Developer Services
Southern Water
Sparrowgrove House
Sparrowgrove
Otterbourne
Hampshire
SO21 2SW

Your Ref
EG/98/14/PL
Our Ref
PLAN-008815
Date
23/02/2015

Proposal: Construction of 3 No. two storey detached houses with new access..
Site: Rear of 59 Elm Grove, Barnham, PO22 0HJ.
EG/98/14/PL

Drawing Title
Proposed Drainage Layout
and Flood Flow Routes

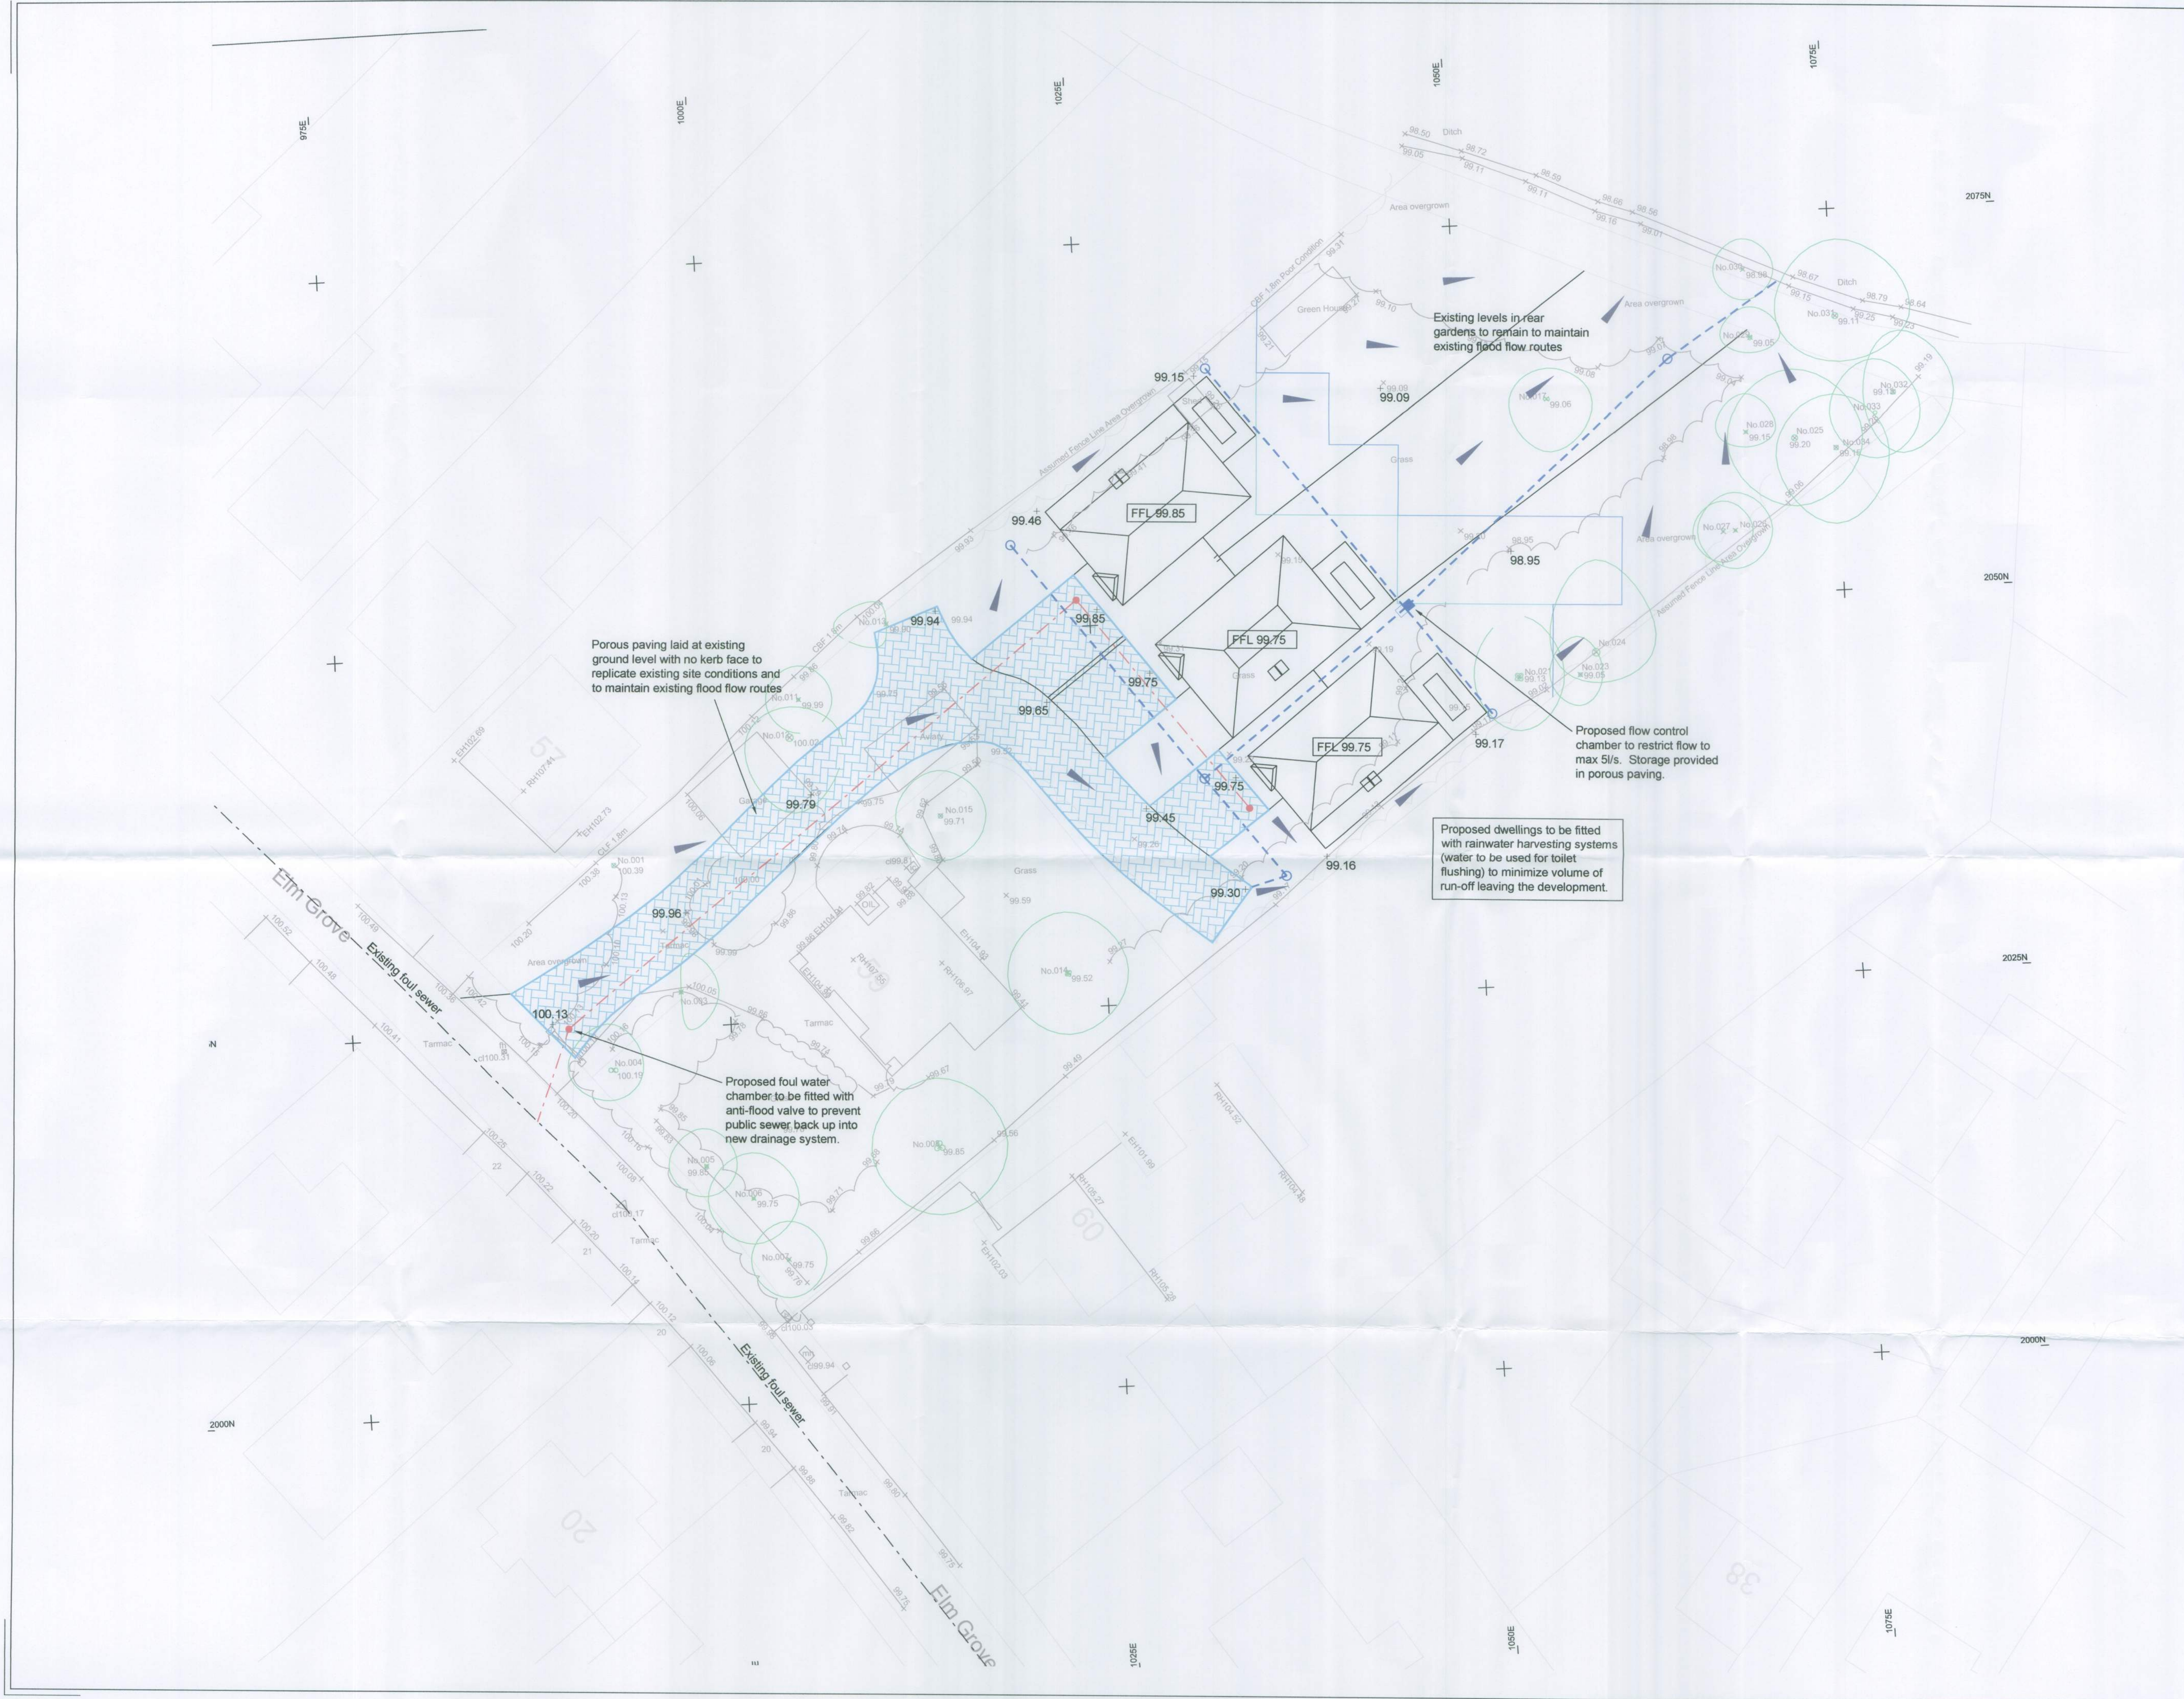
The planning application form makes reference to drainage using Sustainable Urban Drainage Systems (SUDS).

Under current legislation and guidance SUDS rely upon facilities which are not adoptable by sewerage undertakers. Therefore, the applicant will need to ensure that arrangements exist for the long term maintenance of the SUDS facilities. It is critical that the effectiveness of these systems is maintained in perpetuity. Good management will avoid flooding from the proposed surface water system, which may result in the inundation of the foul sewerage system.

Thus, where a SUDS scheme is to be implemented, the drainage details submitted to the Local Planning Authority should:

- Specify the responsibilities of each party for the implementation of the SUDS scheme
- Specify a timetable for implementation
- Provide a management and maintenance plan for the lifetime of the development.

The Council's Building Control officers or technical staff should be asked to comment on the adequacy of soakaways to dispose of surface water from the proposed development.

We request that should this application receive planning approval, the following condition is attached to the consent: "Construction of the development shall not commence until details of the proposed means of foul and surface water sewerage disposal have been submitted to, and approved in writing by, the Local Planning Authority in consultation with Southern Water."

The applicant has proposed a rain water harvesting system that will be used for toilet flushing. Such systems, whilst acceptable in principle, must be installed and maintained to high standards to ensure the protection of the public water supply and avoid cross contamination.

Due to surface water inundation issues in the Lidsey Catchment "The applicant is advised to adopt, where appropriate, the measures in the table "Practical measures to reduce the potential impacts of development".

Developer should look to protect the public sewerage system from inundation and infiltration, which contribute to flooding in unfavourable conditions.
